Ribble Valley Borough Council
Council Offices
Church Walk,
Clitheroe
Lancashire
BB7 2RA

Phone: 0300 123 6780
Email: developeras@lancashire.gov.uk
Your ref: 3/2026/0430
Our ref: 3/2026/0430/HDC/KW
Date: 13 August 2026

Location: Land off Higher Road Longridge PR3 2YX
Proposal: Proposed erection of two holiday lodges with associated works to existing access to facilitate new access track/parking.
Grid Ref: 361987 438447

Figure 2 Proposed landscape layout and site plan

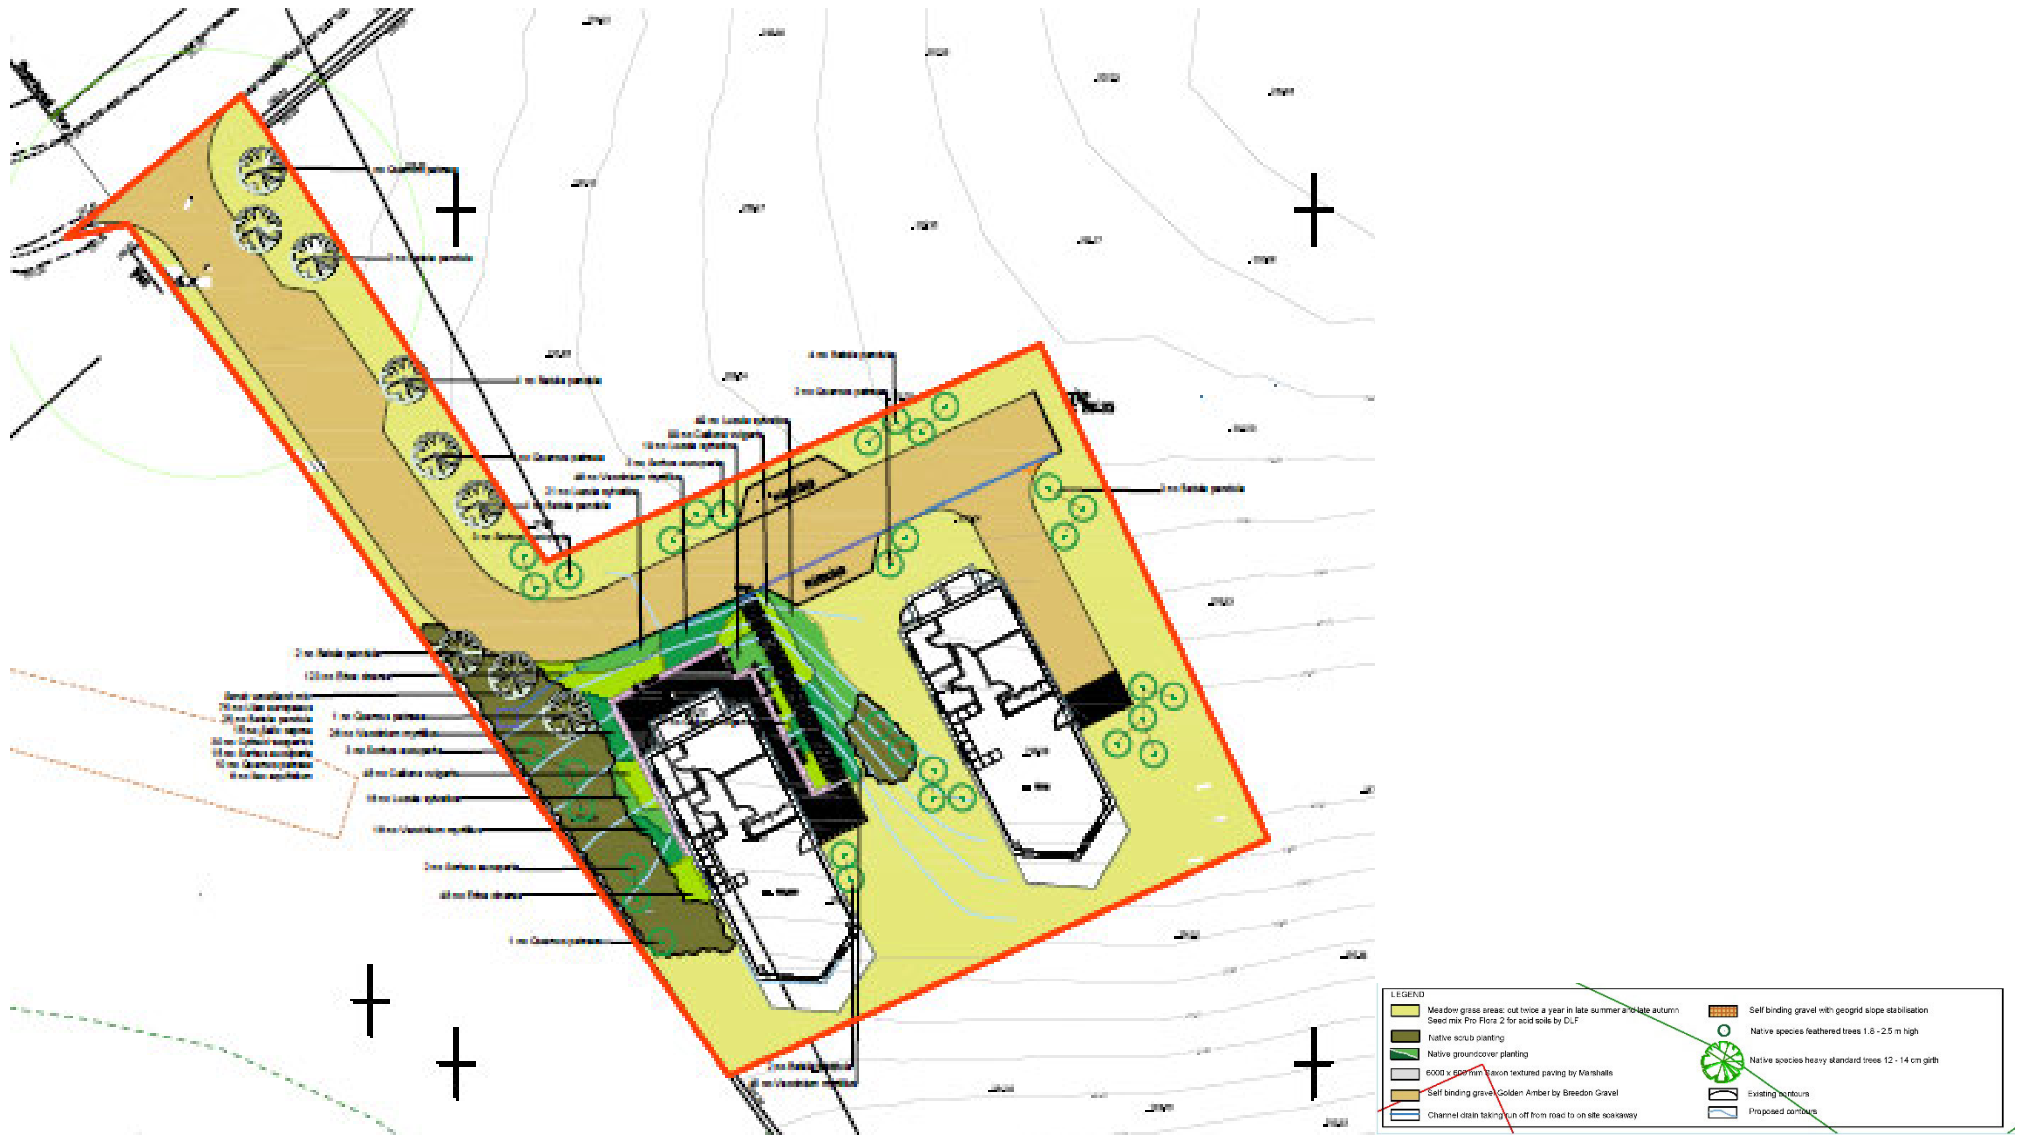
The application site contains two areas of parking adjacent to the internal access track which leads to the turning head. For clarity, the LHA would expect each 2 bedroom holiday let to be supported by 2 off street parking spaces. This should be clearly shown within an amended plan.

A turning area has been provided within the site which will support ingress and egress in forward gear.
